Planning Ref:- R/190/13

I would like to submit my objections to the above planning reference.
re:- plot of land to rear of No.s 20 and 22 Broadmark Lane, Rustington.

DRAWING TITLE
PROPOSED ELEVATIONS AND
STREET ELEVATION

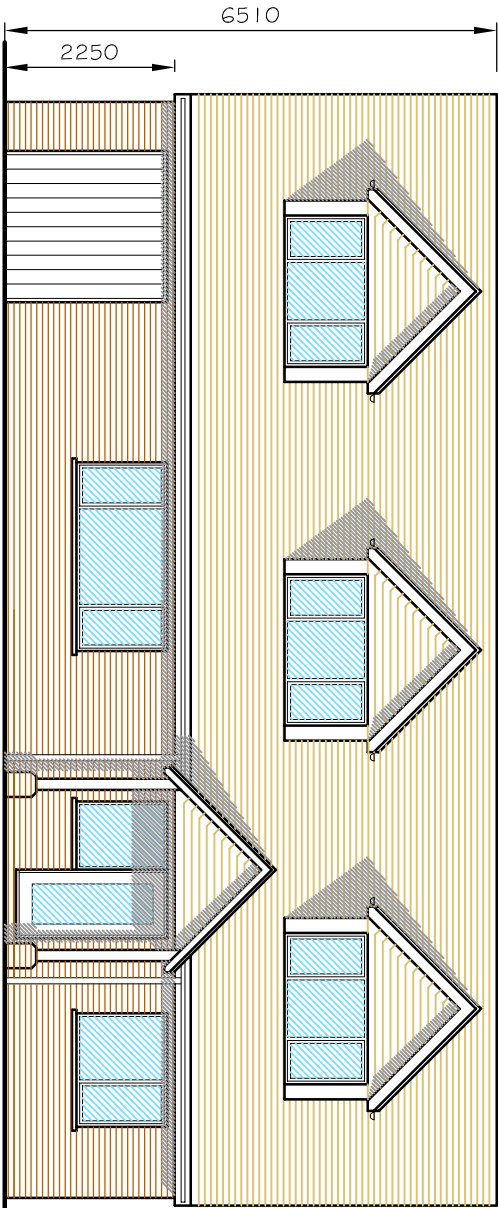
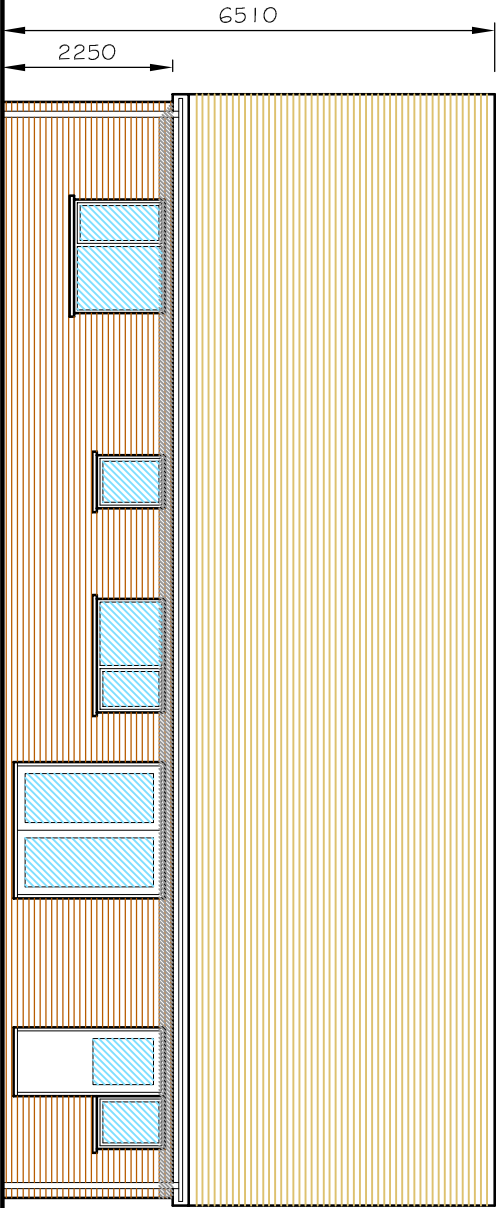
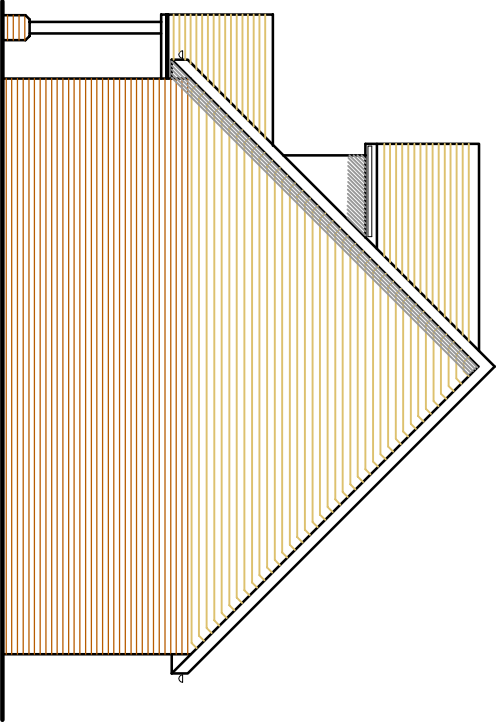
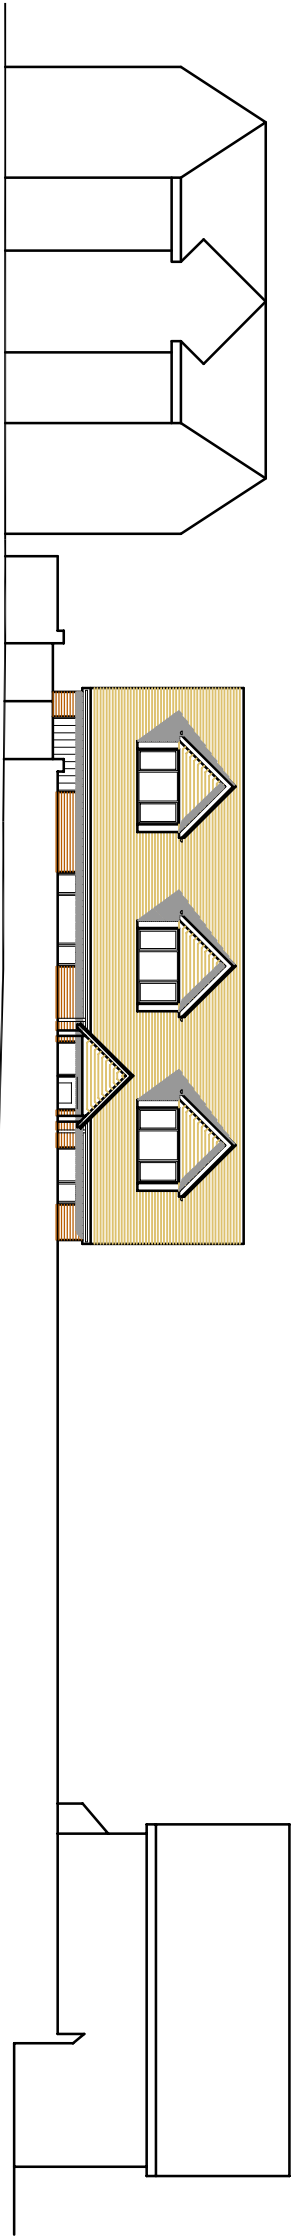
The proposed build will be very cramped, overbearing and very intrusive to the neighbouring properties of 4 Broadmark Way and 20 and 22 Broadmark Lane.

The area has a vast majority of 1930's/40' houses, this new build will be completely out of character for this area.

DRAWING TITLE
SITE LOCATION AND LAYOUT PLANS

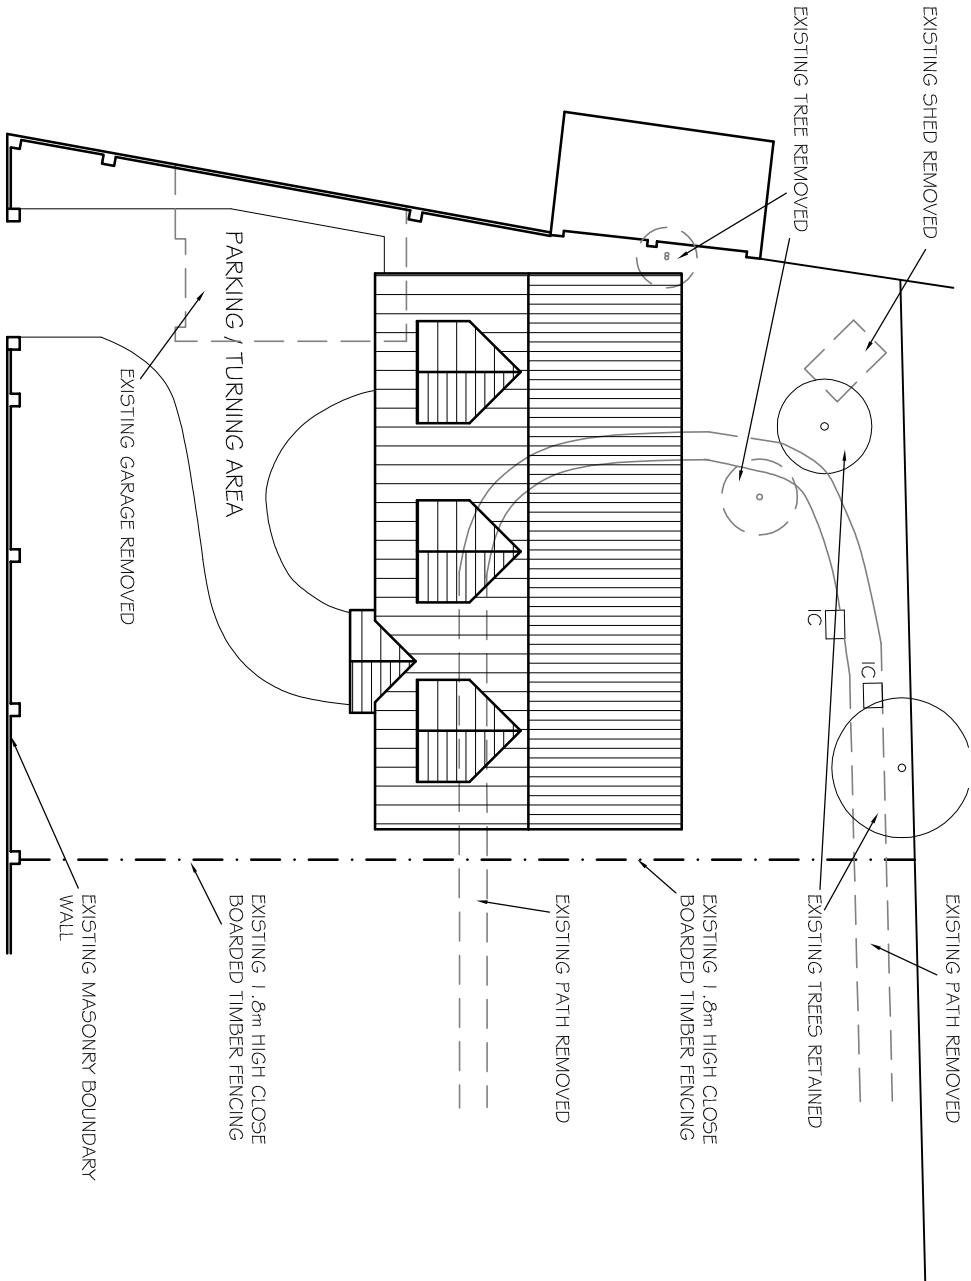
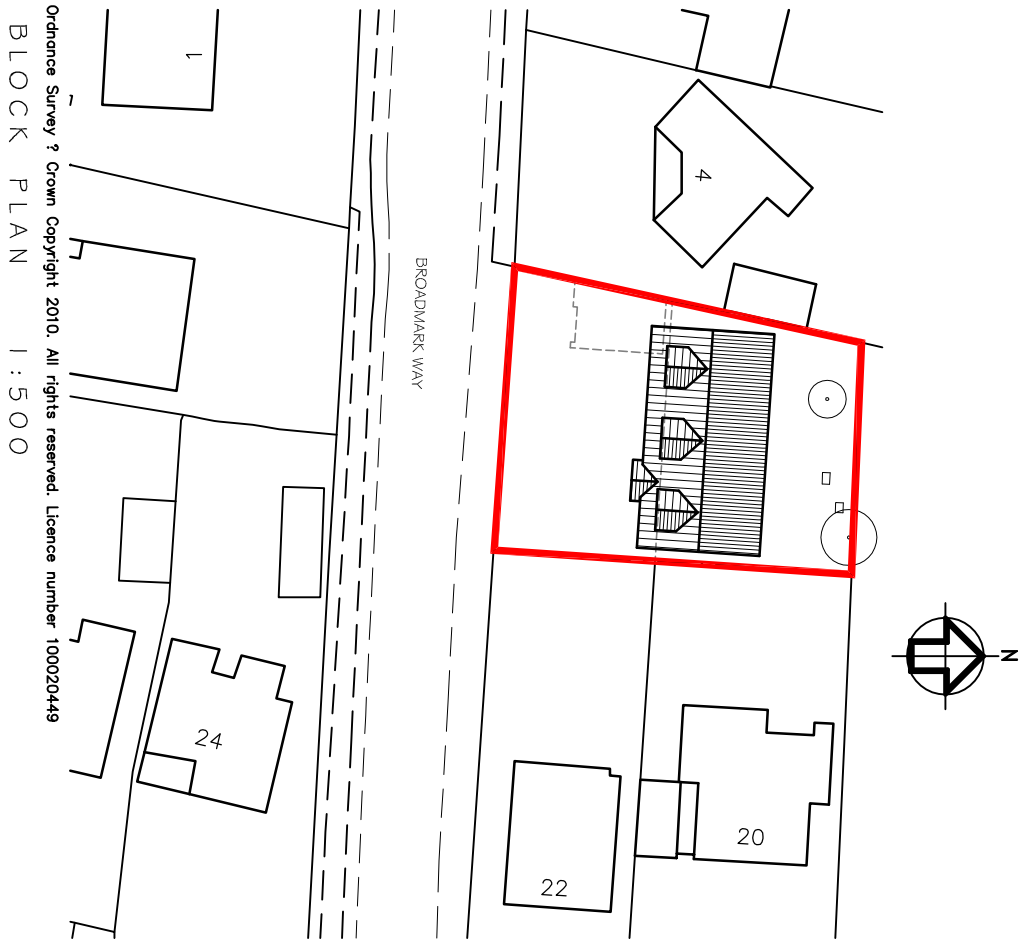
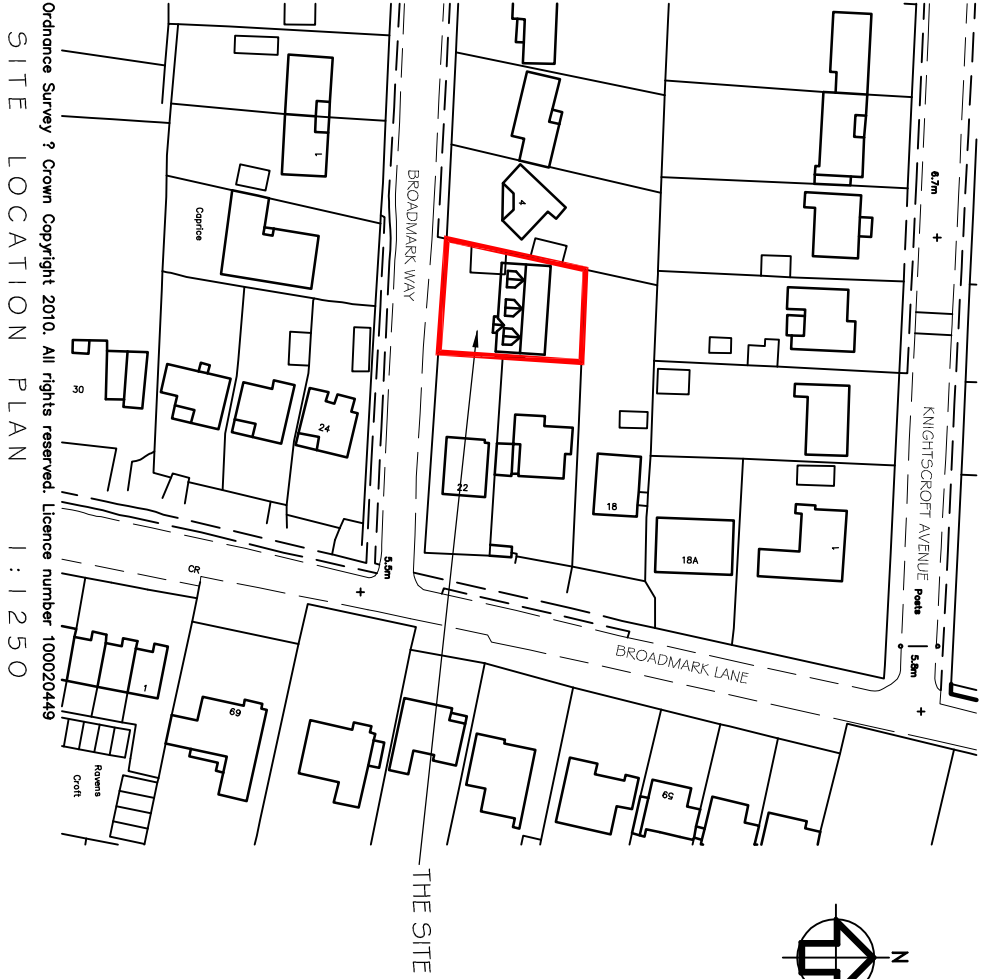
The plot of land is far too small for the proposed build.

Plans for a family sized house bring with them the requirements for parking several vehicles for private and business use.
This site will not have that space available.
